Engineers Comments Regarding Surface Water Drainage

Application Reference:	F/40/26/PL	Reviewer Reference:	ADC/EXT5/AF
Planning Officer:	Kathryn Welch	Date of Review:	29/09/2026
Site Name:	Environment Agency, Ford Depot Station Road Ford BN18 0BH		
Application Description:	Replacement of existing Portacabin with new single storey modular cabin for use as an ancillary building to the existing site. Excavate grounds of mixed material to create trench for new power, water and drainage. Install drainage pipework and associated items, including connection to existing, new or planned network. Install electrical meters, transformers and associated items as required. Excavations to be finished in concrete to match existing hardstand. New planters, wildlife houses and greenspace. Is in CIL Zone 3 (Zero Rated) as other development.		
Assessment Number:	1

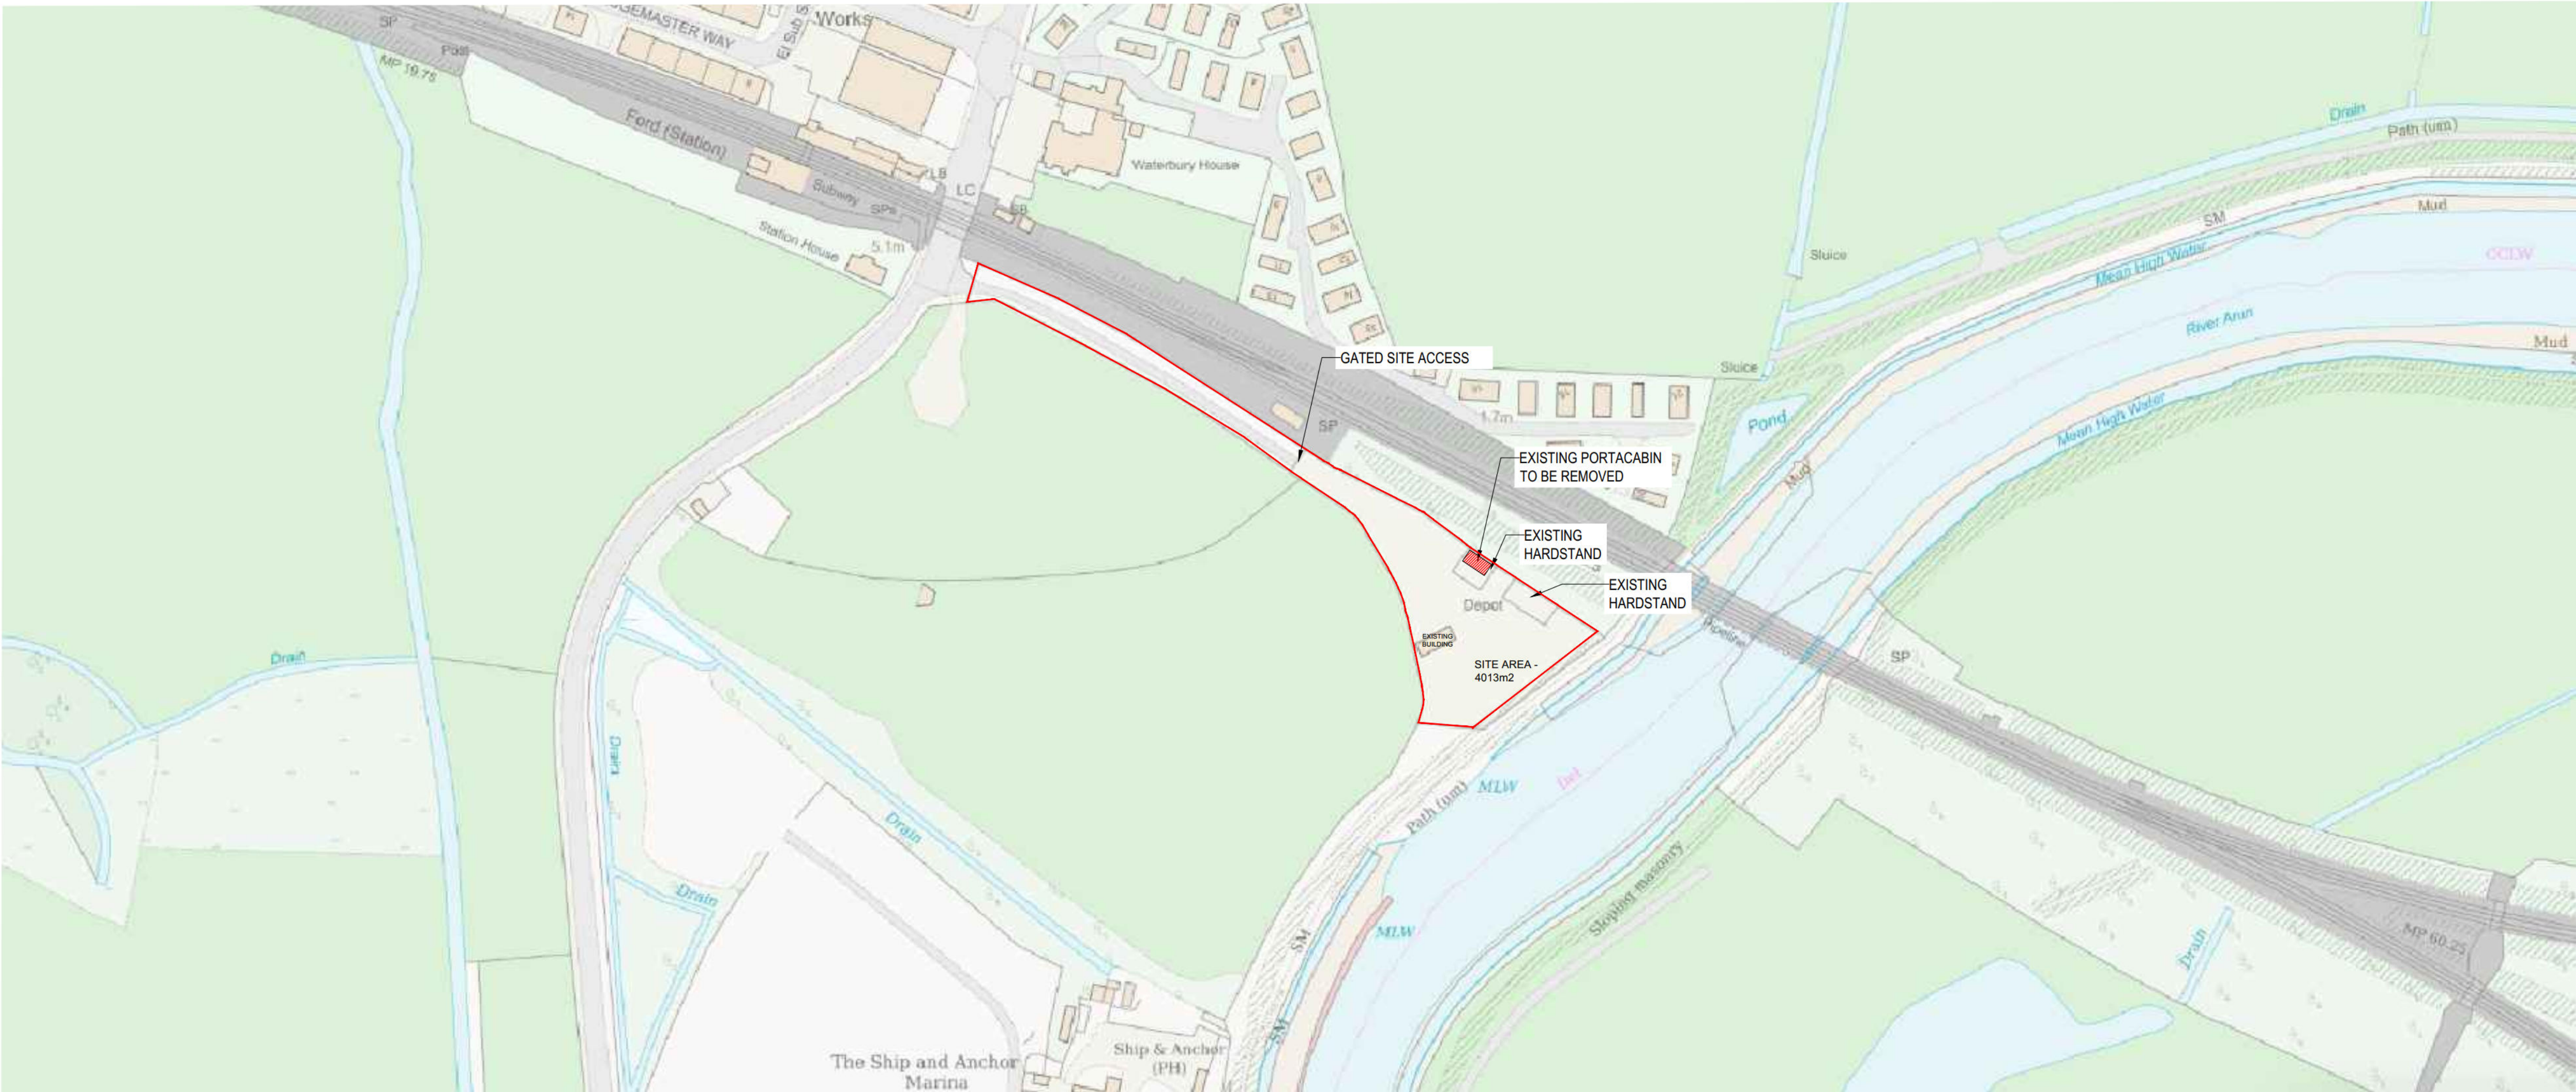
- 1.1. No rainwater harvesting is required. The site will not be able to support infiltration and connection to the River Arun (Main River) is acceptable in principle.
- 1.2. The Civils Layout shown on drawing 3000 rev P5 indicates direct discharge to the River Arun by gravity with below ground storage (due to being tide locked at high tide).
- 1.3. Further evidence is required to confirm that the system can operate without significant flooding the site when tide locked. See comments below in Section 3.

- 3.2. The calculations provided do not appear to incorporate a downstream surcharge due to tide locking. Further information should be provided to demonstrate that the system can drain to the river without significant flooding including during the Mean High Water Spring [MHWS] downstream conditions with the temporary storage provided as a gravity system. Note the design storm does not need to be stored entirely below ground but any surface ponding should be intentional and assessed to be an acceptable hazard.

3.5. The Civils layout shows storage for tide locking and states this has been calculate for a 4 hour tide locked scenario. Calculations should be provided showing a tide locked outfall based upon the future year MHWS.

3.6. The current design does not demonstrate the site can be effectively drained to the receiving watercourse, therefore, we **Object** to the application.

Cellular Storage
FSR: 100 years: Increase Rainfall (%): +45: 240 mins: Winter

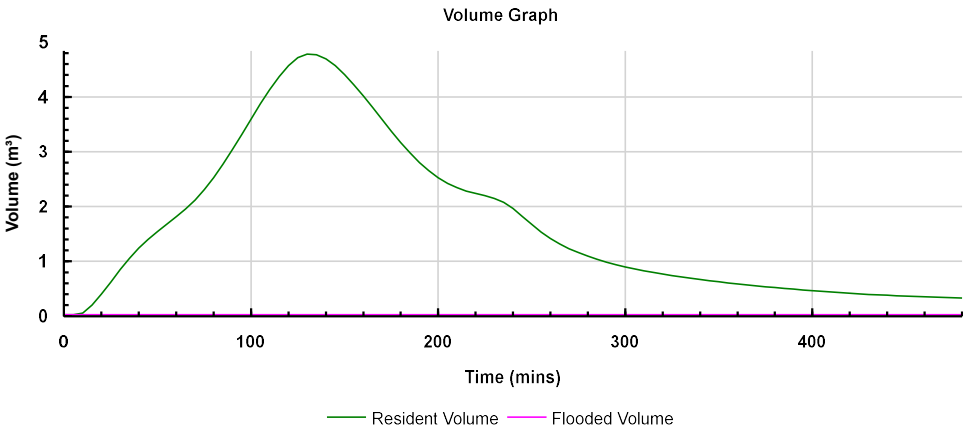
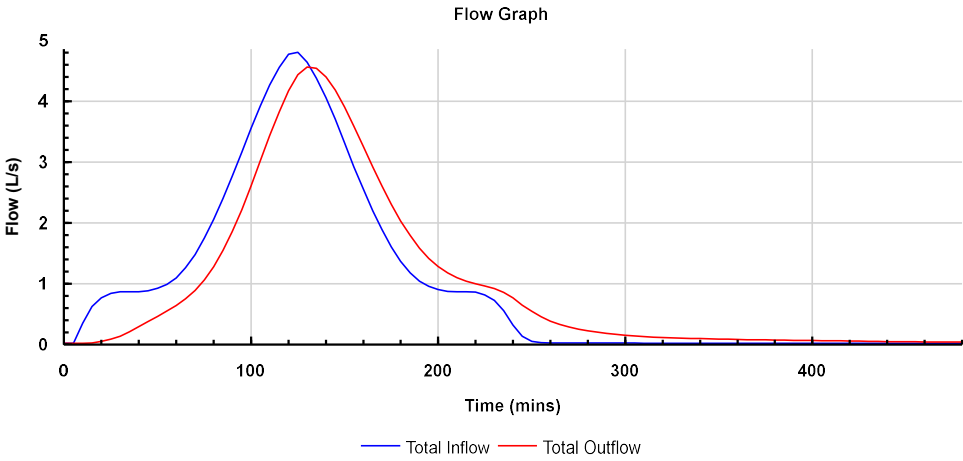
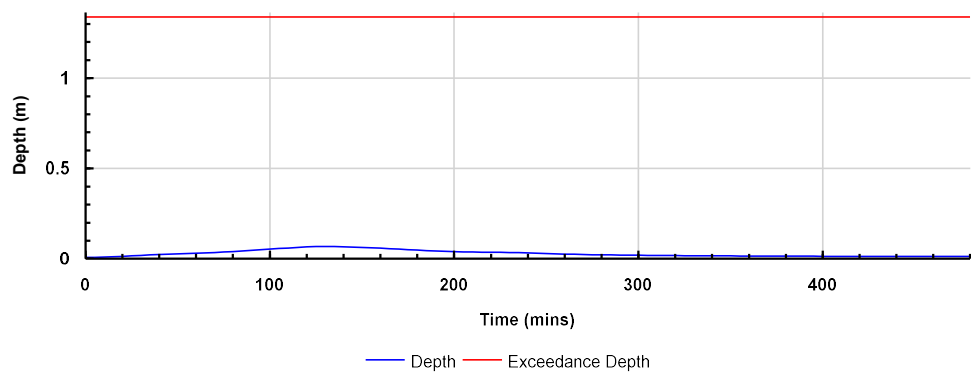
- 3.3. The current calculations are based upon FSR rainfall data and CV values of 0.75 summer and 0.84 winter. These parameters do not comply with the National SuDS Standards and Arun DC guidance.
